KITTITAS COUNTY

MEMORANDUM

TO: Kari Braniff, CDS
FROM: Christina Wollman, Planner II *CW*
DATE: August 14, 2008
SUBJECT: Corbett Short Plat SP-08-34

CORBETT SHORT PLAT
 PART OF SECTION 27, T. 17 N., R. 19 E., W.M.
 KITTITAS COUNTY, WASHINGTON

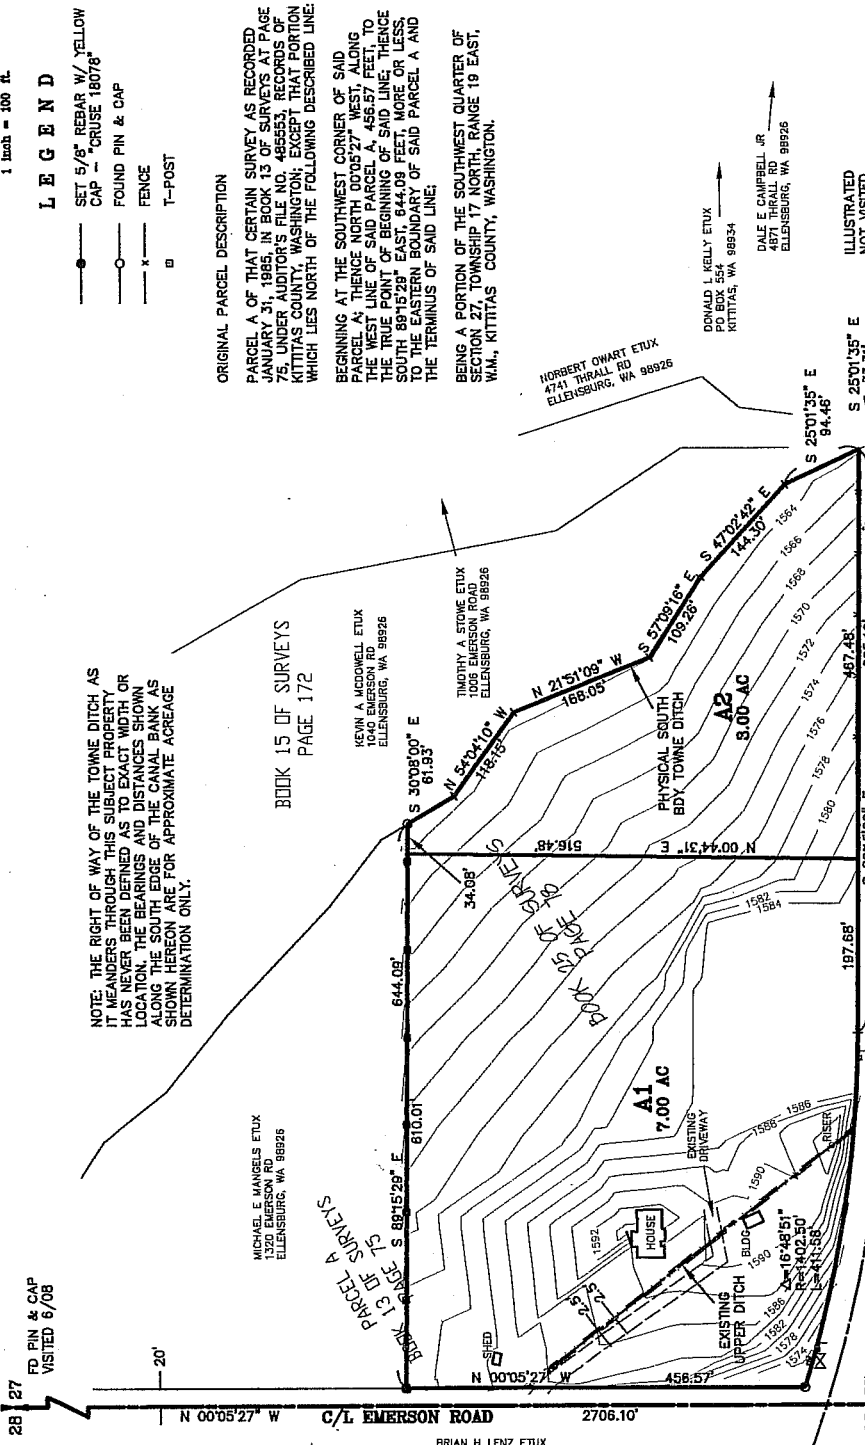
Kittitas County Road Standards require all new accesses to meet spacing requirements. Thrall Road is classified as a Rural Major Collector with a speed limit of 50 mph and a spacing requirement of 1000'. Access to Lot A2 will not be able to meet this spacing requirement and a variance will be required prior to preliminary approval.
